Recommendation Report for Planning Permission for Works or Extension to a Dwelling

REF NO: FP/55/20/HH

LOCATION: 17 First Avenue
Felpham
PO22 7LG

PROPOSAL: Side extension and replacement garage roof including the conversion of garage to habitable use.

PROPOSED ELEVATIONS

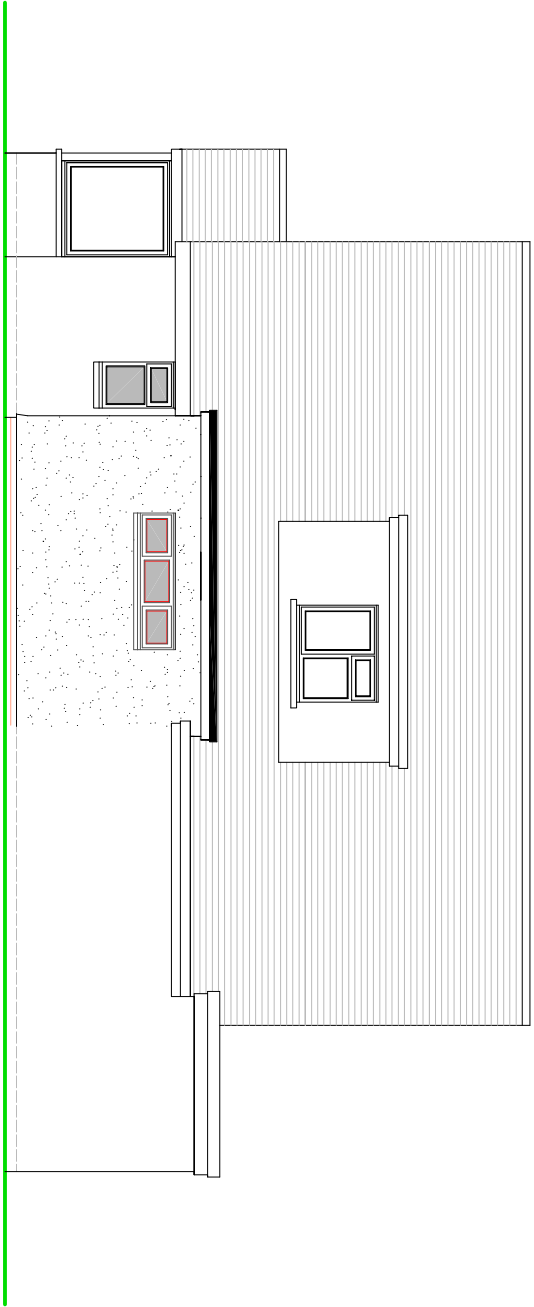
The extension to the side of the property will have a depth of 4.25m, with a flat roof height of 2.7m. It will have a width of 3m which retains around 1m to the southern boundary. As a result of the siting and separation, the addition is not deemed to result in adverse impacts upon the neighbouring property to No.19.

There will be an additional window to the front which will overlook the street scene and small windows to southern elevation. Whilst the side windows look towards the neighbouring property's rear garden, with No.19 situated further forward than the host dwelling, the windows are at a high level at 1.7m above finished floor level and with the development at single storey, it is not considered it will give rise to significant overlooking.

To the rear of the extension, the existing garage will be re-roofed however the alteration is not visible and not deemed to result in adverse impacts with the size of the structure remaining the same.

SITE PLAN - 1/500

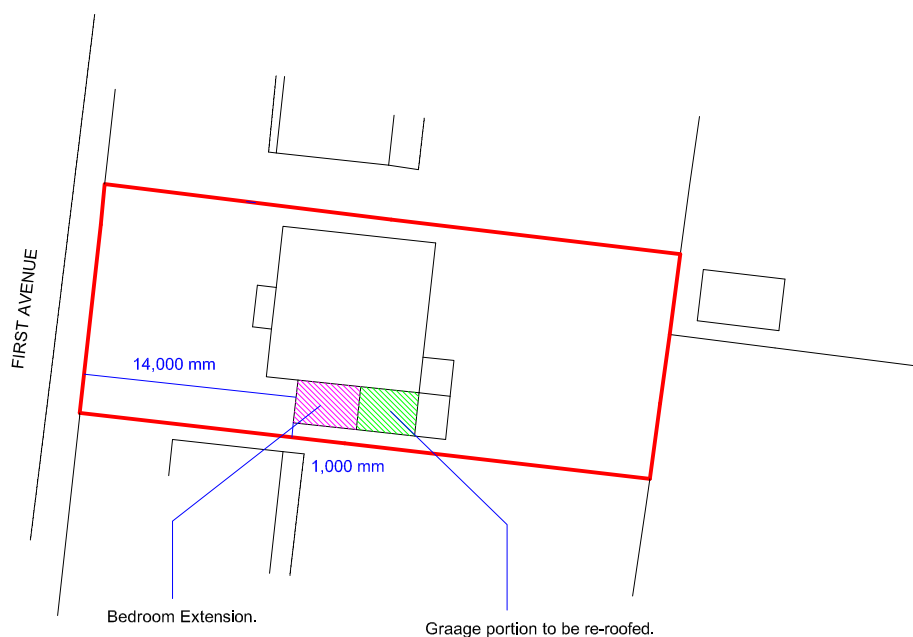
There is a garage to the southern elevation of the property and an extension will be constructed to the front of this. This does not extend beyond the principal elevation and retains 14m the front boundary of the property which ensures the development does not appear unduly dominant.

Due to the siting of the development, it will restrict the use of the garage and therefore result in the loss of a parking space.

The front of the property however has sufficient space for at least 4 spaces and the alteration is not deemed to result in adverse impacts upon parking or highway issues.
